From: wilpshire parish council <wilpshireparishcouncil@gmail.com>
Sent: 14 November 2020 11:50
To: Planning
Cc: wilpshire parish council
Subject: planning consultation comments from Wilpshire Parish Council

3/2020/0883 1 Mayfair Crescent, Wilpshire

Proposed Ground Floor Plan

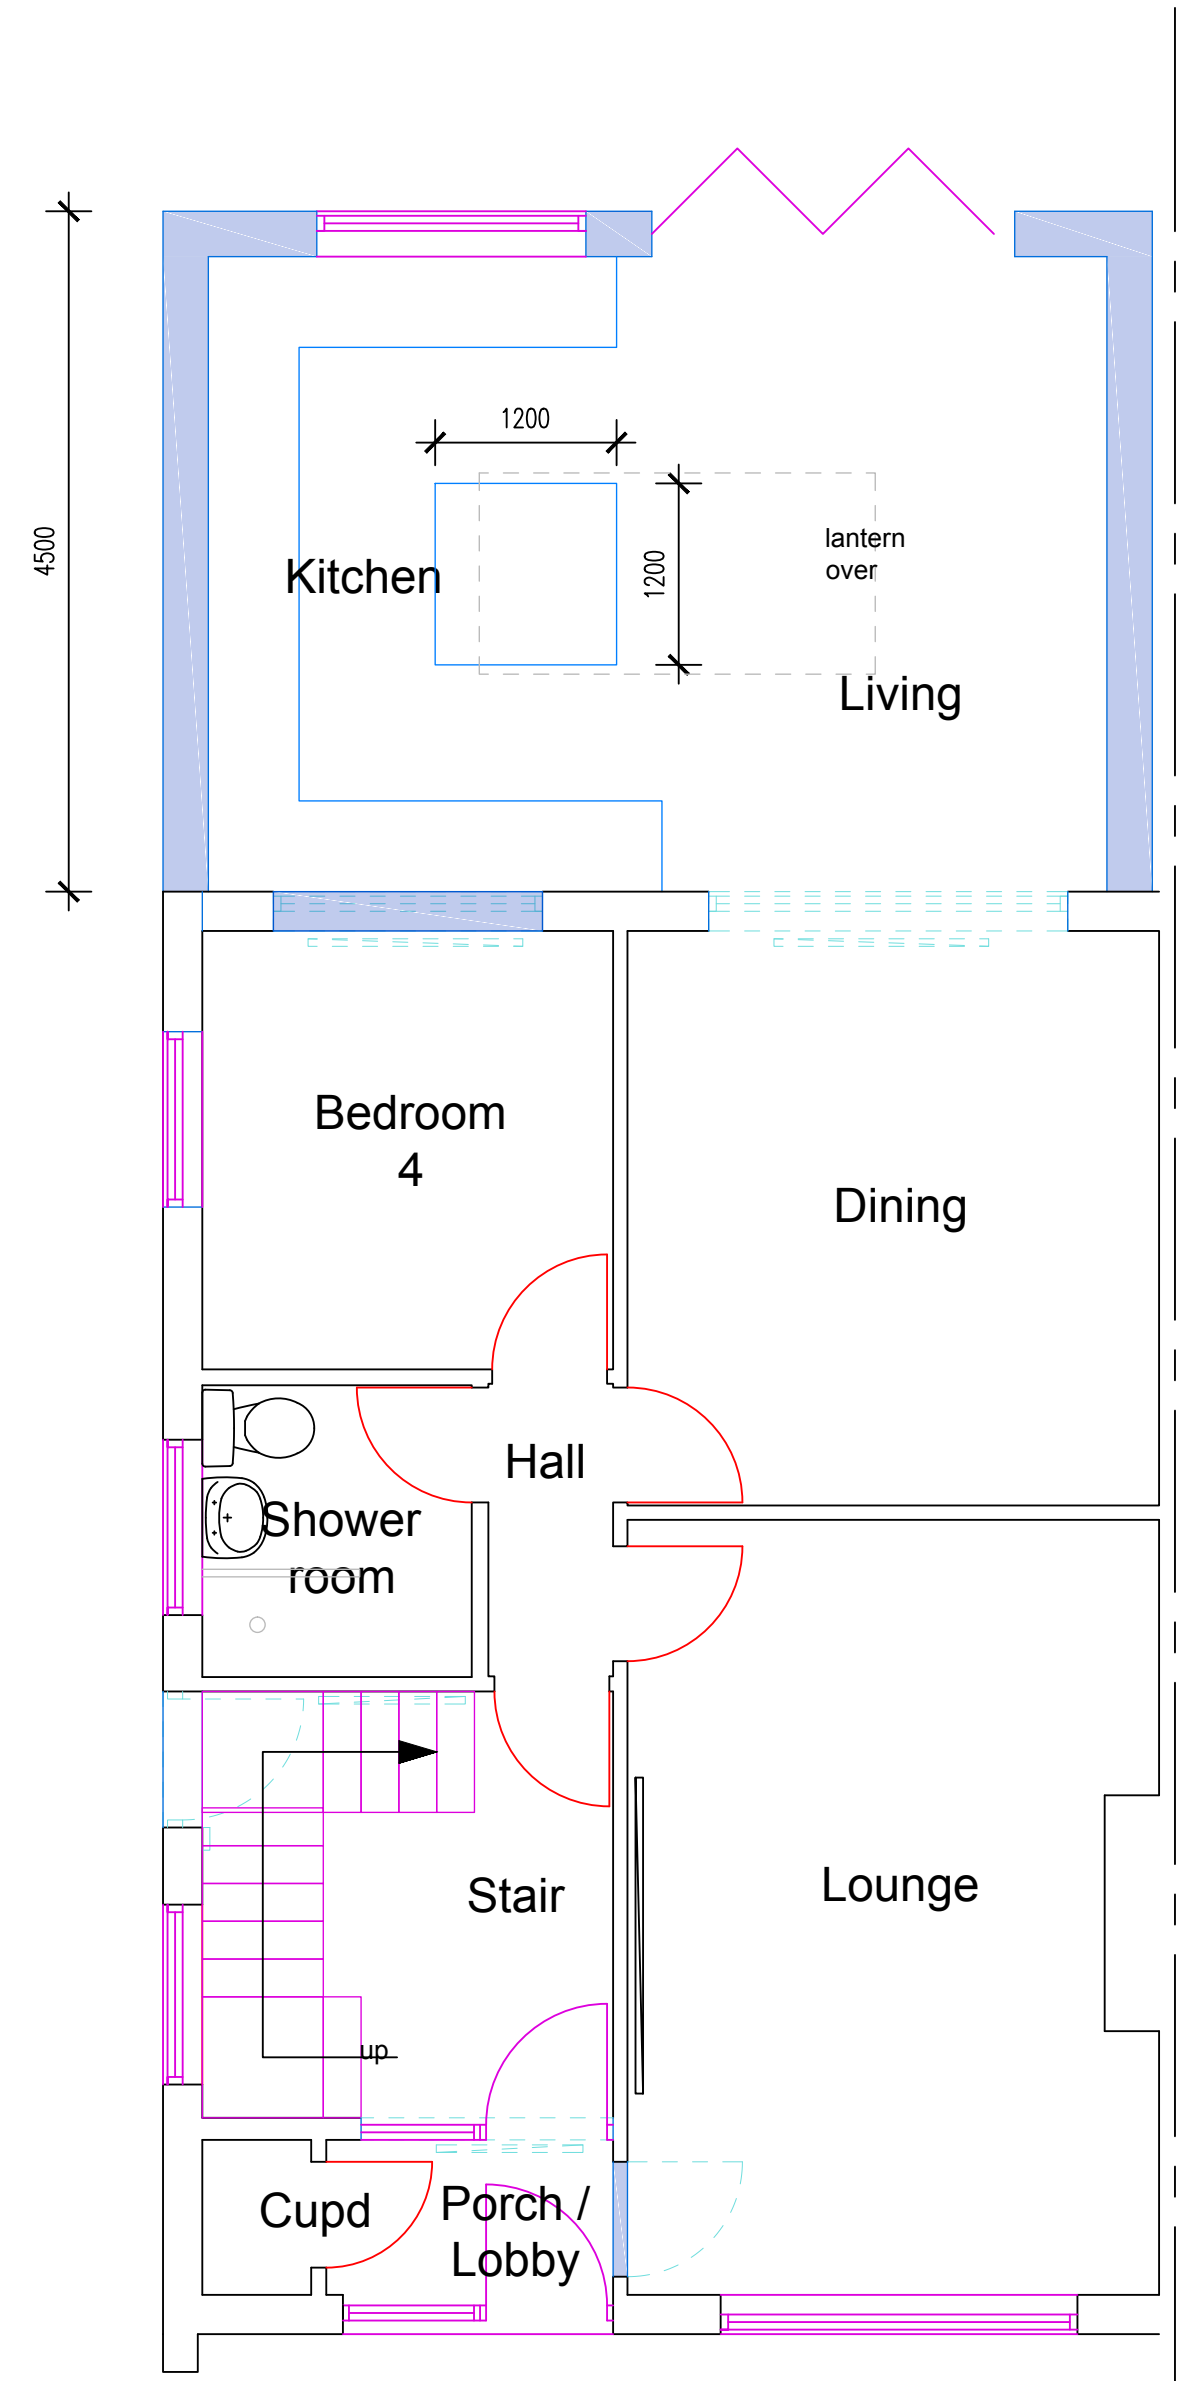
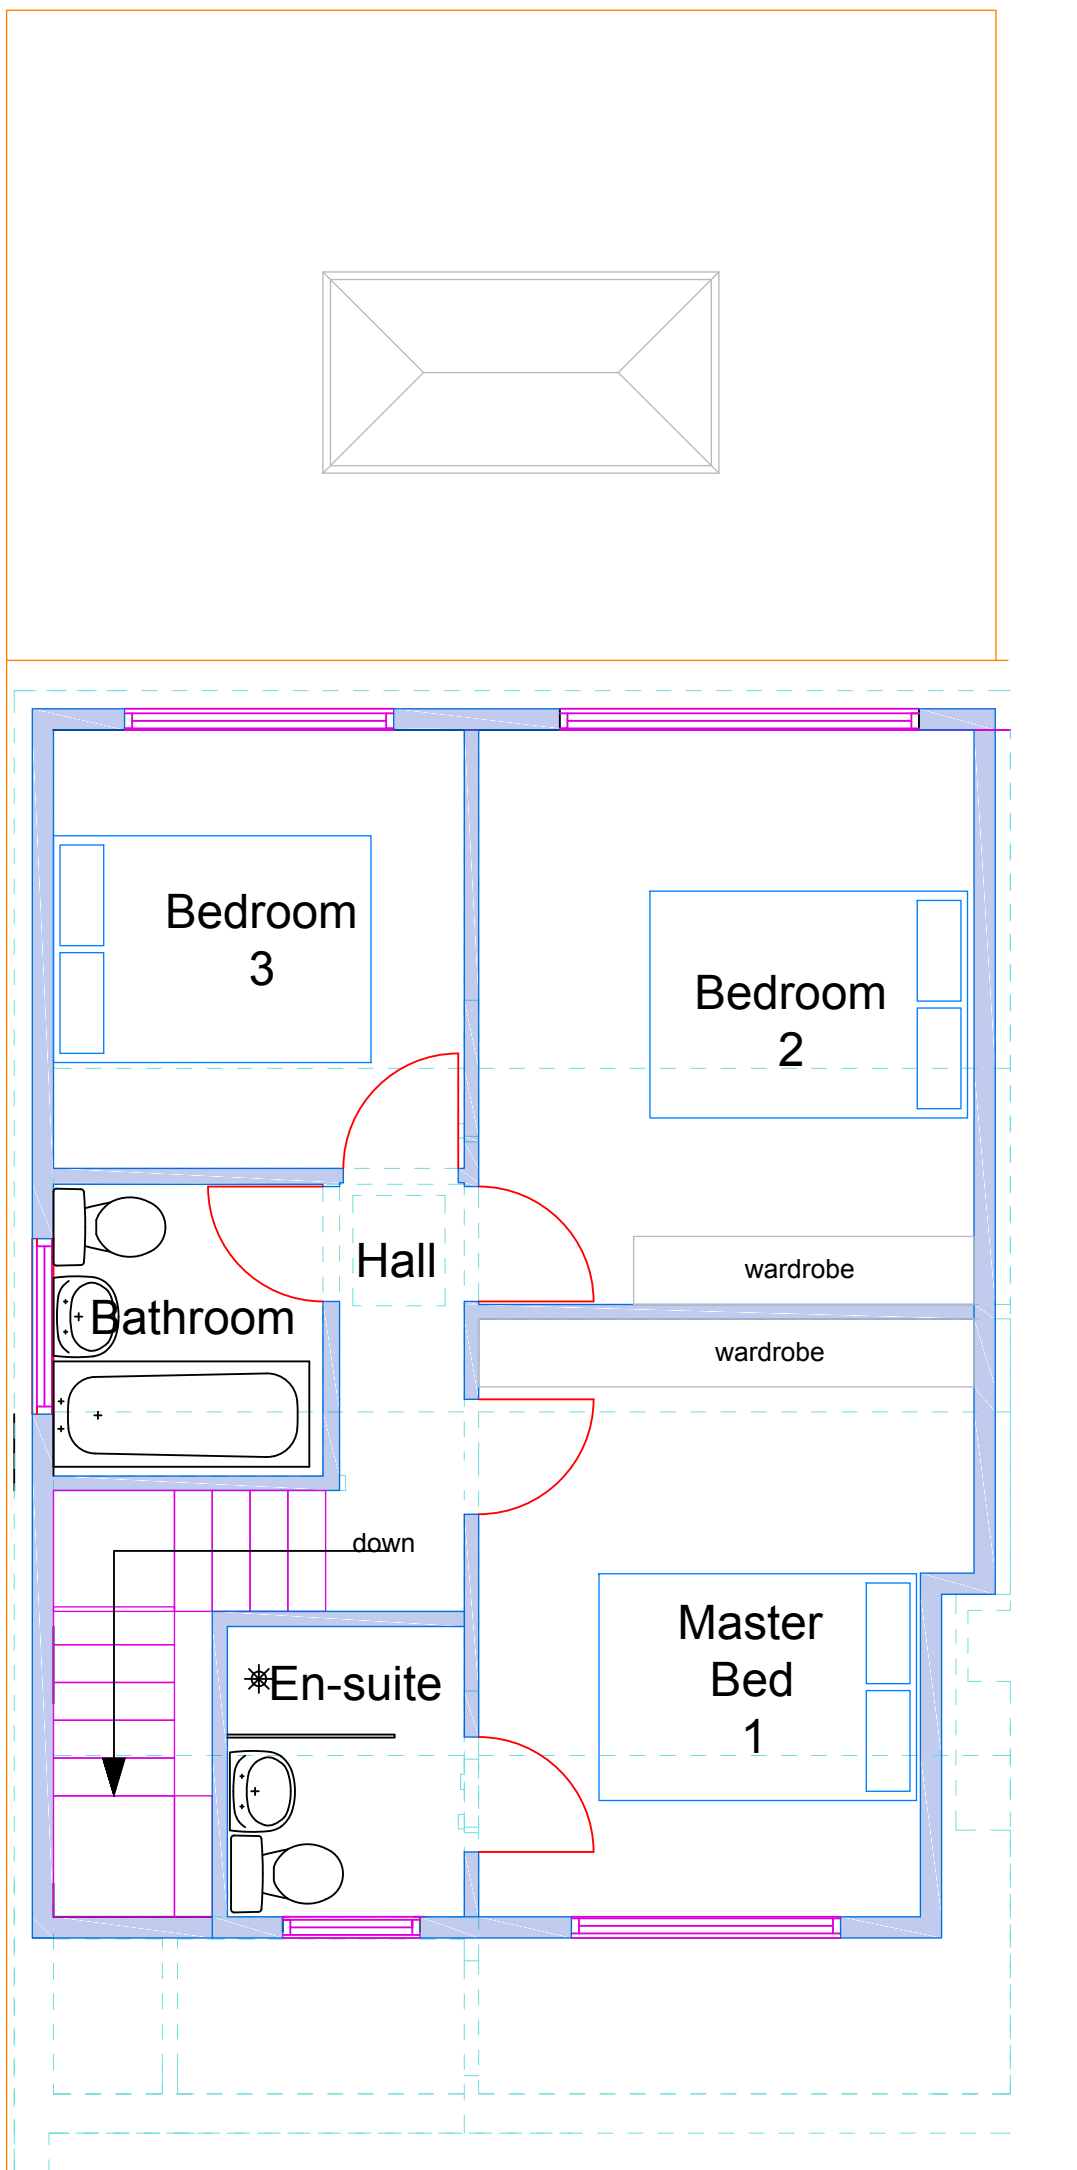
Wilpshire Parish Council objects on the grounds of overdevelopment on a limited sized plot. The footprint is to increase by almost 50% in addition to adding a first floor on nearly all of the original bungalow. The Council is also concerned about an apparent lack of parking provision.
